Tween Bridge Solar Farm

9.9 Statement of Common Ground with Natural England

Deadline 2 [19th May 2026]

Statement of Common Ground

Project	Tween Bridge
Drawing Title	Non Breeding Bird Mitigation Plan
Scale	As Shown (Approximate)
Drawing No.	16413/P14g
Date	July 2026
Checked	TLR/RR

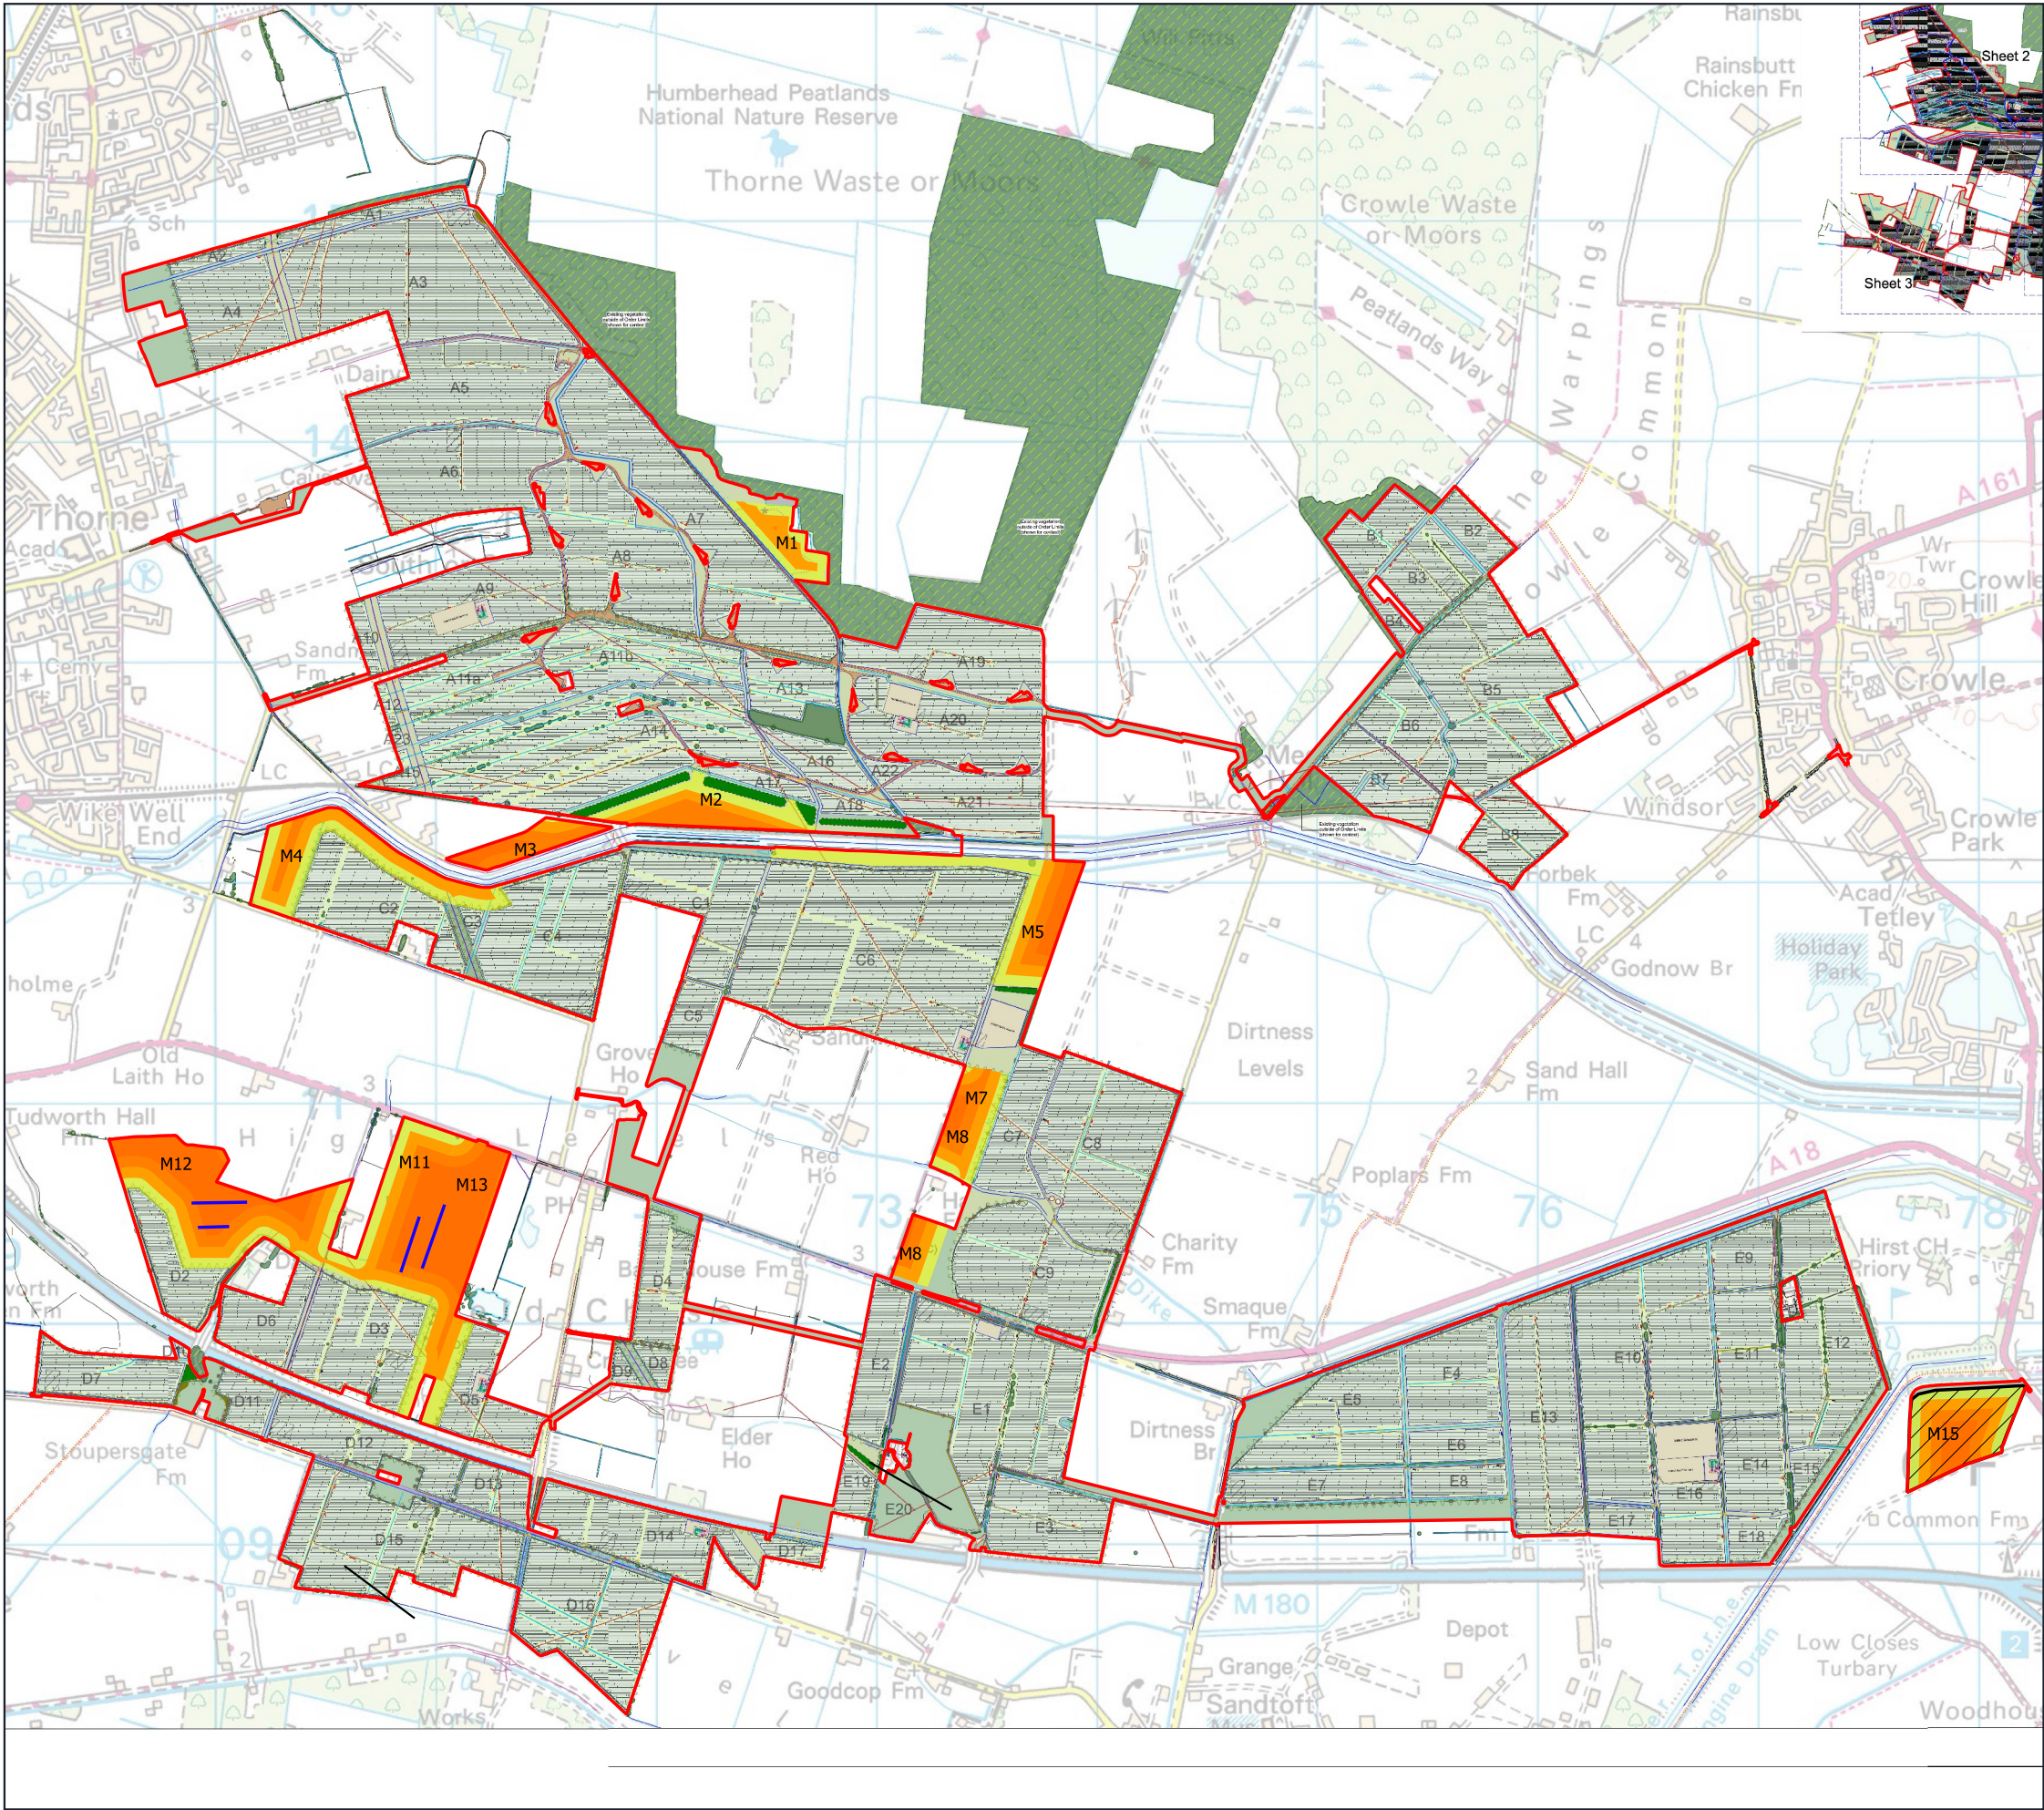
<p>Has the removal of the M1 parcel has been factored in to the total?</p> <p>If M1 is the area to be removed from the mitigation strategy - it must be</p>	<p>to reflect bird use where possible. Given the mobility of SPA bird species, and the location of the Order Limits approximately 7.7 km from the Humber Estuary SPA, birds will utilise suitable habitat across a large area. This is supported by non-breeding bird survey results that show use of the Order Limits changed between the survey periods, although also show notable lapwing use in the northern part of the Order Limits close to proposed mitigation areas.</p> <p>The Applicant confirms that the parcel M1 is not proposed to be removed, rather it is proposed to be reduced in extent and would therefore continue to perform a mitigation function for breeding and non-breeding birds. Nonetheless, as detailed in Table 1-1: Non-Breeding Bird Mitigation Land Calculations at the end of this document, the mitigation calculations do not include parcel M1 due to its proximity to wind turbines</p>

<p>demonstrated how this will be accounted for.</p> <p>Could clarification be provide as to whether this is in addition to the above 43.67ha? Aware this will likely be set out further in the mitigation strategy</p> <p>We confirm this remains under discussion - We acknowledge further details of the proposed approach but as discussed in call on 24 February - we will need to see the updated mitigation strategy accounting for suggested changes and demonstrating in full the carrying capacity</p>	<p>The Applicant confirms that as seen in Table 1-1: Non-Breeding Bird Mitigation Land Calculations at the end of this document, that the calculations do not include parcel M1 and the figures provided demonstrate there is sufficient mitigation land, based on using Bird Days calculations and the habitat requirements and ecological knowledge of the species being mitigation.</p> <p>The Applicant confirms that 108.84ha is in addition to 43.67ha.</p> <p>As detailed in Table 1-1: Non-Breeding Bird Mitigation Land Calculations at the end of this document, and shown in Figure 1: 16413_P16a_600m Buffers_TLR_RR, at the end of this document.</p> <p>The Applicant confirms that reducing in extent parcel M1 would not affect the mitigation strategy and that sufficient mitigation is provided</p>

<p>Report to Inform Habitat Regulations Assessment [Document Reference 5.3 Revision 4] and provided as part of Figure 1 within this document.</p> <p>Several mitigation parcels larger than 10ha with at least 150 m open vistas are provided, including M12 and M13.</p> <p>A total of 43.67ha of mitigation land with 150 m open vistas is located beyond 600 m of wind turbines, in line with point NE3 (see below), and is available for lapwing. Bird Days calculations demonstrate that 24.99 ha is required for lapwing (Appendix 2 of the Report to Inform Habitat Regulations Assessment [Document Reference 5.3 Revision 4]), confirming that more mitigation land is provided than required. Additional mitigation land within 600 m of turbines, including parcels M1 and M2, is also available, and lapwing have been recorded using these areas, therefore ensuring that additional land is available for this species.</p> <p>When considering mitigation land beyond 600 m of turbines, 108.84ha</p>

<p>remains available for pink-footed geese and mallard, the remaining functionally linked species recorded within the Order Limits, even when accounting for the 43.67ha provided for lapwing . Bird Days calculations indicate that 22.98 ha is required for pink-footed geese, and as this species forages in similar habitats to lapwing without competing for the same resources, more than sufficient land is provided.</p> <p>Bird Days calculations are not applicable to mallard, as detailed in the Report to Inform Habitat Regulations Assessment [Document Reference 5.3 Revision 4],. However, substantial mitigation land remains available beyond 600 m of turbines even after accounting for lapwing and pink-footed geese (85.86 ha), in addition to enhancements to the ditch network which will improve habitat suitability for this species.</p> <p>Table 1.1 provides further detail on the mitigation land calculations.</p> <p>The Applicant confirms that mitigation areas have been selected</p>
